CITY OF ALBUQUERQUE

December 13, 2016

Re: Daycare Center - 6513 Lomas NE
60-Day Temporary Certificate of Occupancy- Transportation Development
Architect's Stamp dated 10-13-16 (J18D045)
Certification dated 12-08-16

AS101

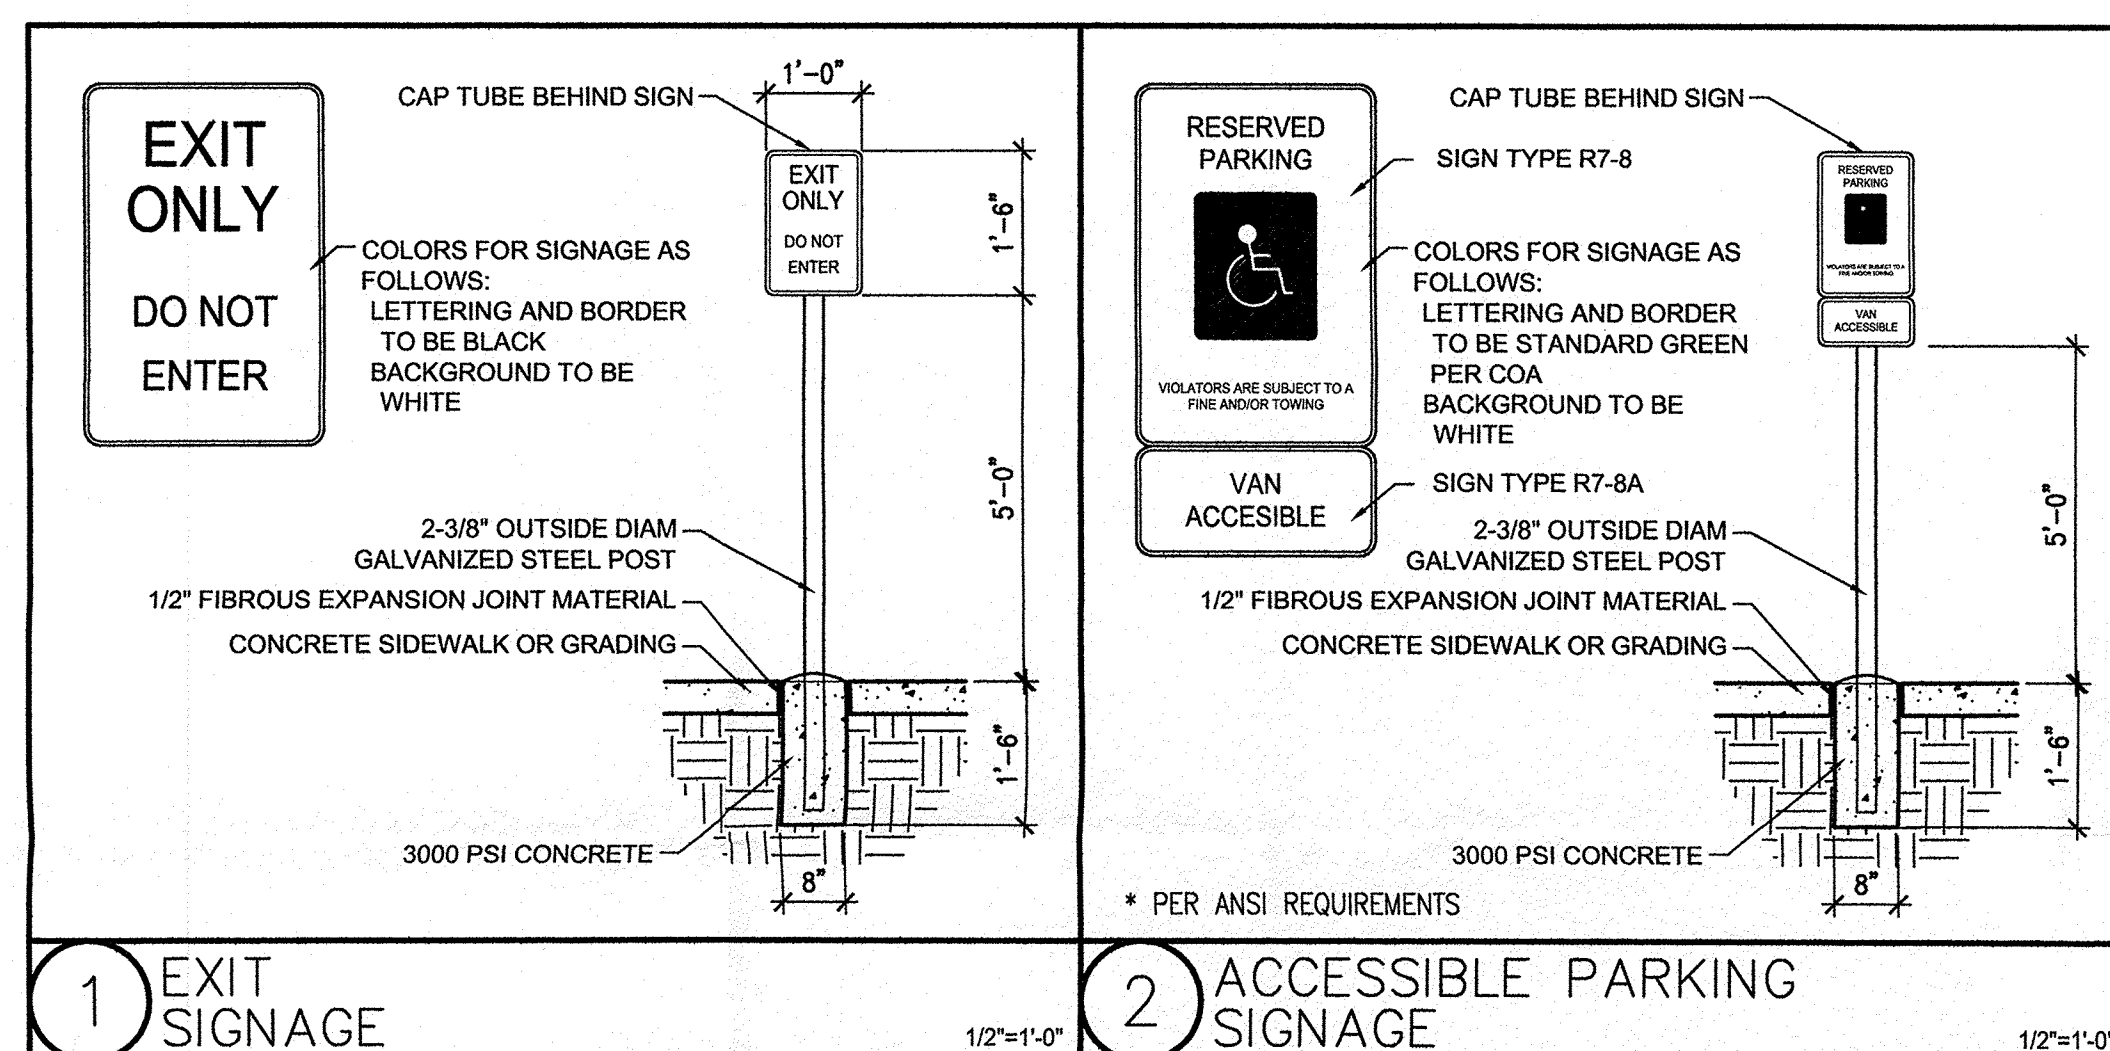
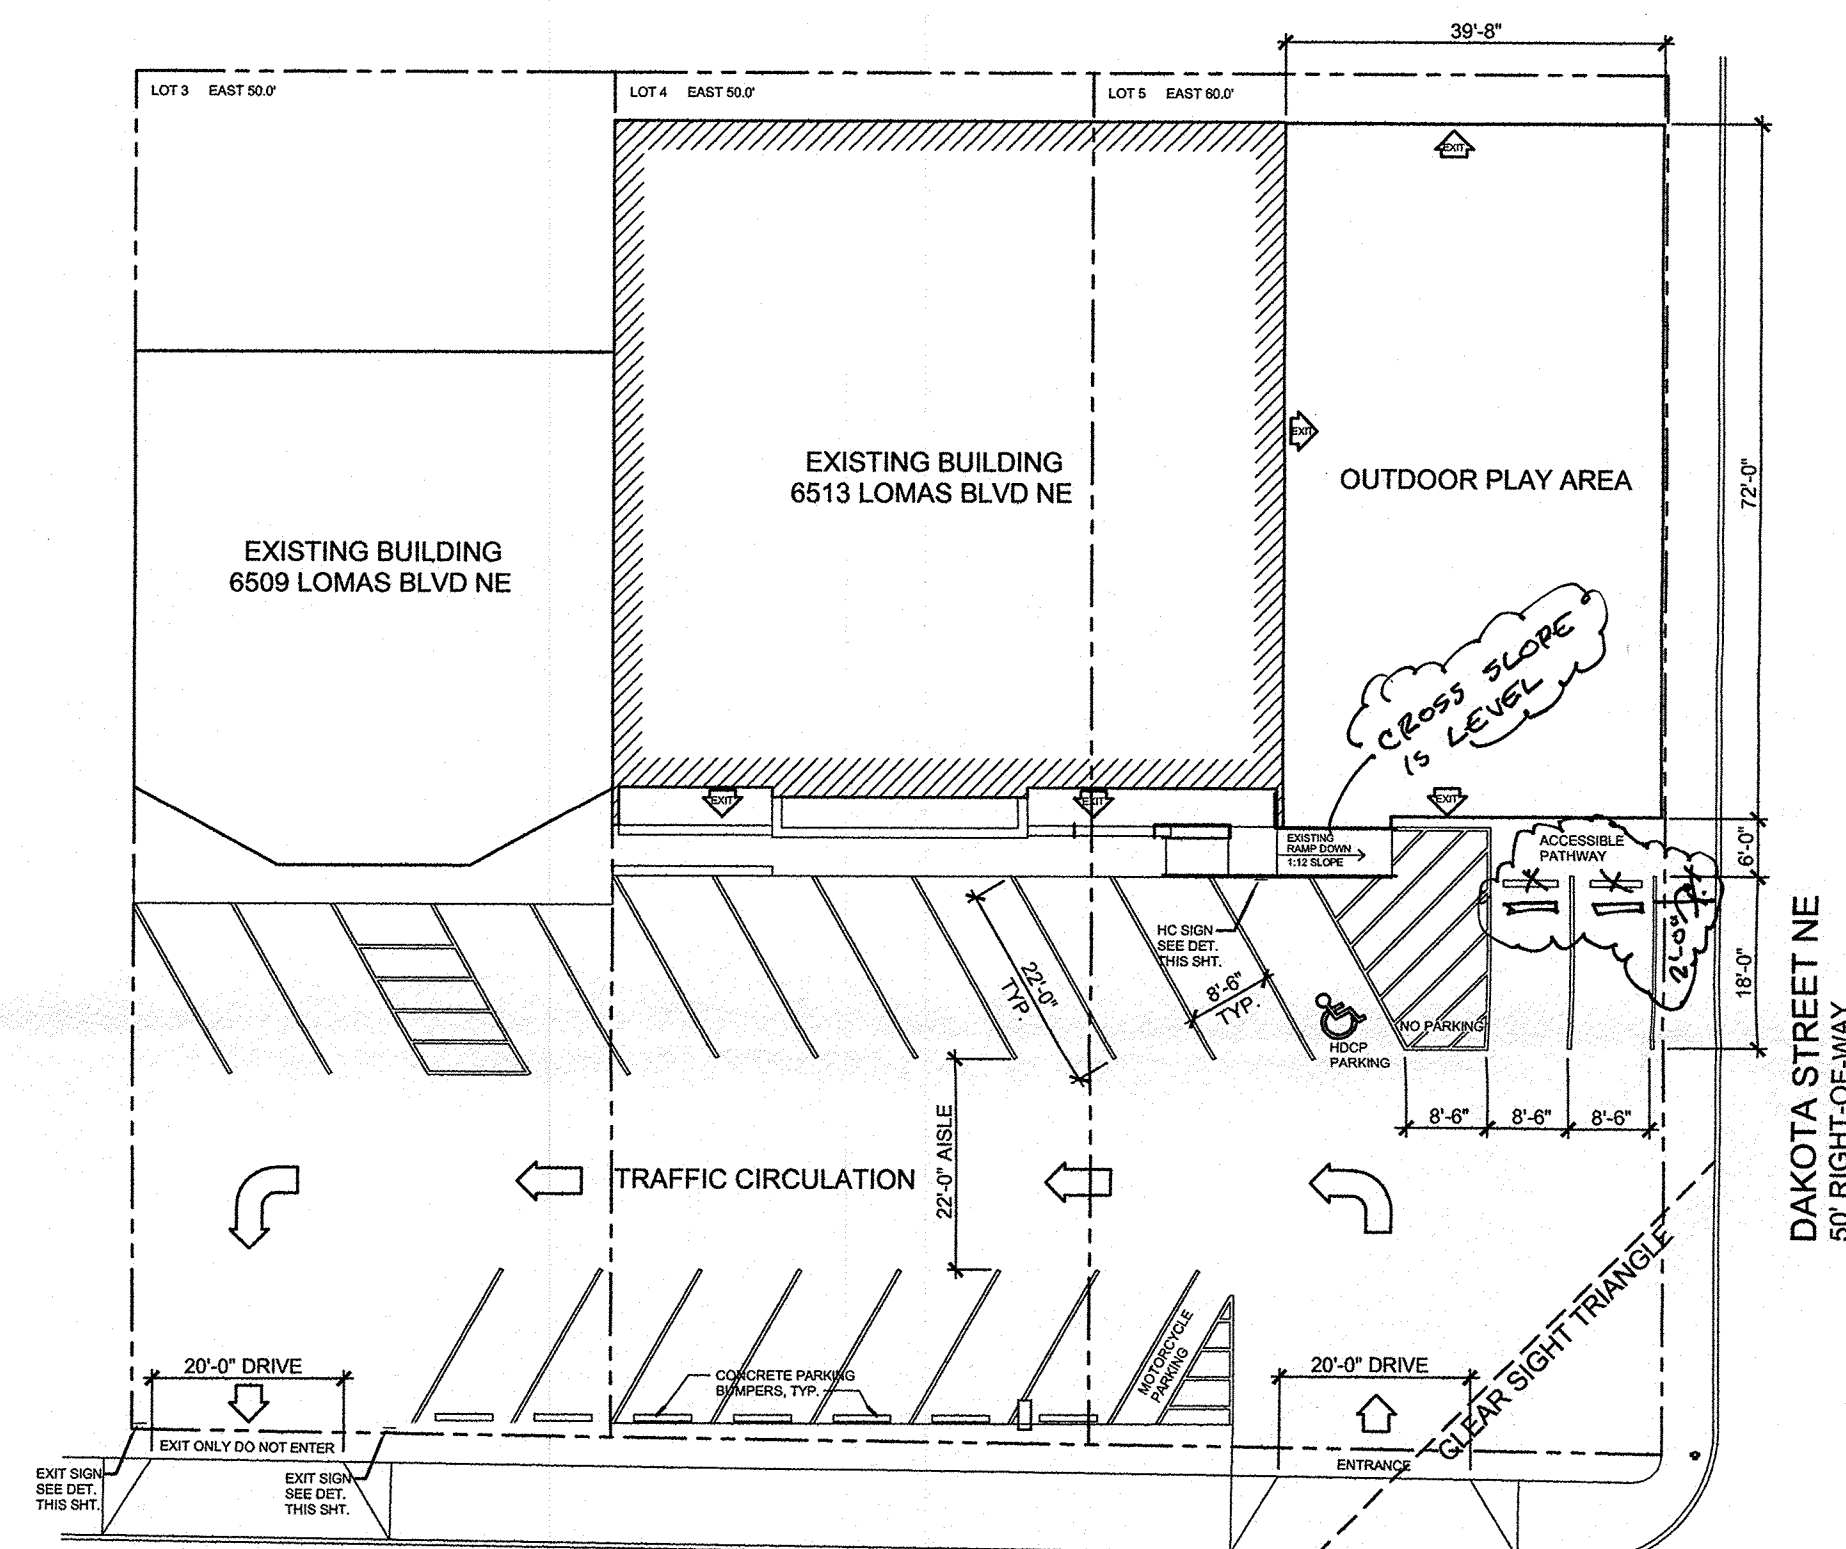
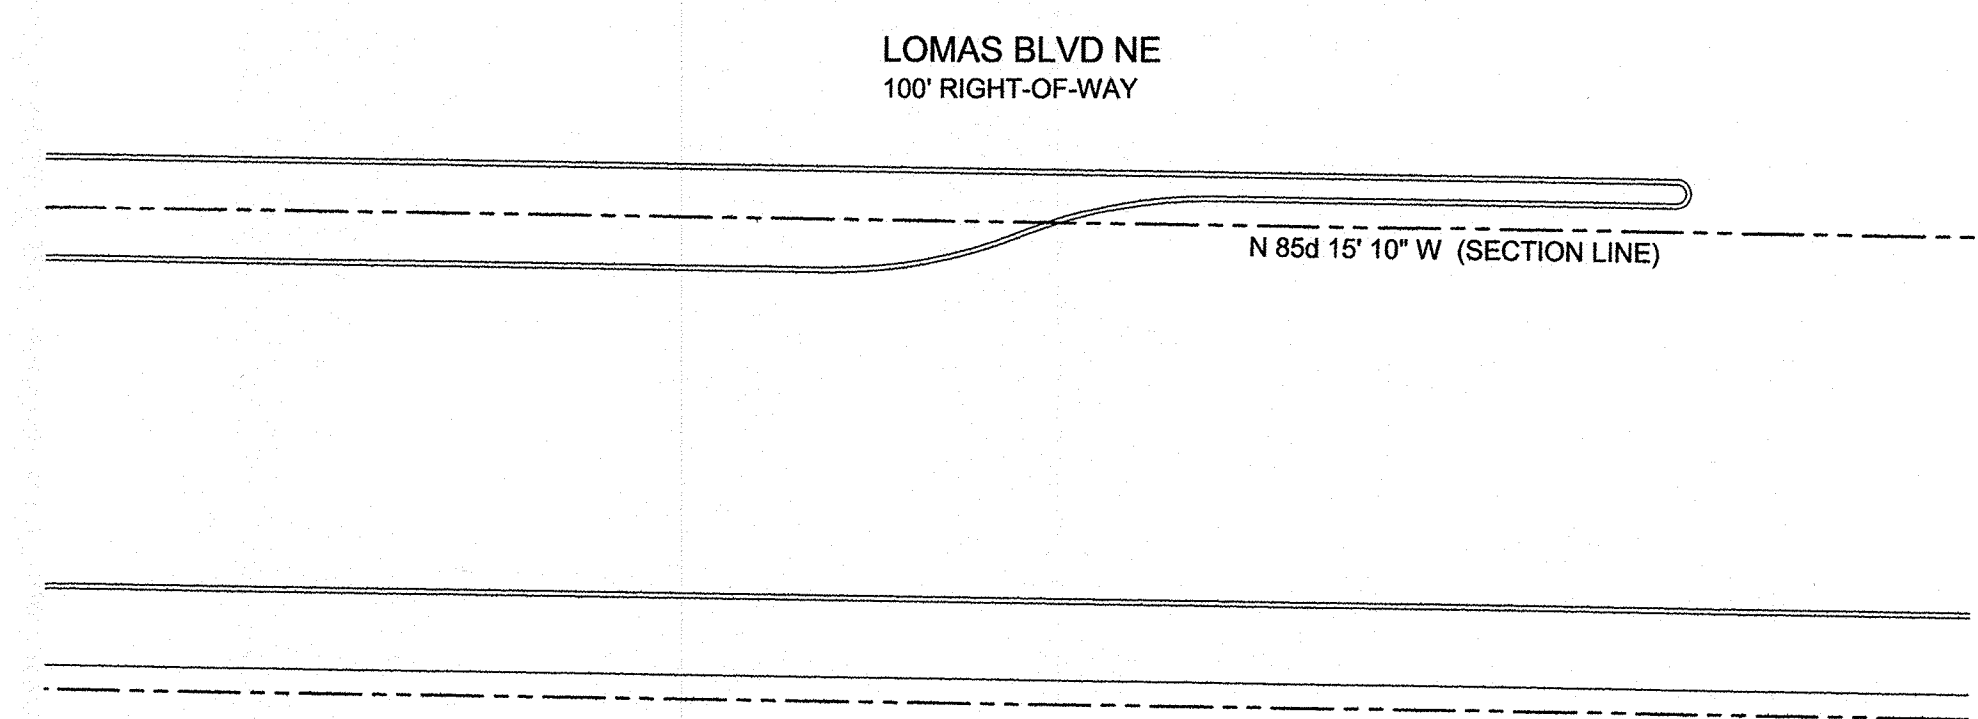
1. The ADA accessible parking sign must have the required language per 66-7-352.4C NMSA 1978 **"Violators Are Subject to a Fine and/or Towing."** Please call out detail and location of HC signs.
2. The ADA access aisles shall have the words **"NO PARKING"** in capital letters, each of which shall be at least one foot high and at least two inches wide, placed at the rear of the parking space so as to be close to where an adjacent vehicle's rear tire would be placed. (66-1-4.1.B NMSA 1978)
3. The ADA parking space has a clearly visible, blue, International Symbol of Accessibility painted on the pavement at rear of the space (66-1-4.1.E NMSA 1978) or MUTCD recommends a white symbol on a blue background.
4. Motorcycle parking & signage needs to be added to sight.
